From: Nicola Spencer
Sent: 26 March 2021 20:23
To: [REDACTED]
Cc: Iqraa Malik [REDACTED]
Subject: FW: Mistletoe Farm CM/46/20/HH - Updated Red Line Plan

Thank you for providing the updated block plan. Unfortunately, the dimensions listed on the block plan do not measure to scale. Please amend.

# LOCATION PLAN 1/1250

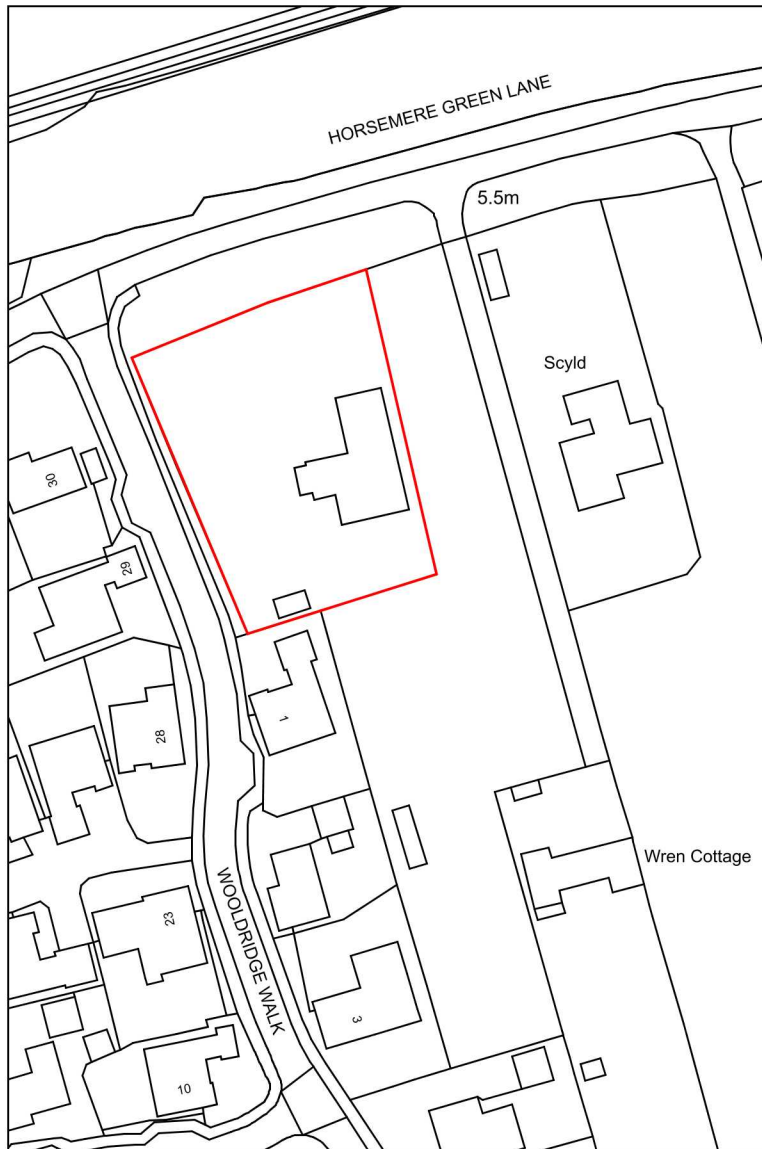
Could you please also update the red line on the Location Plan to match this new outline?
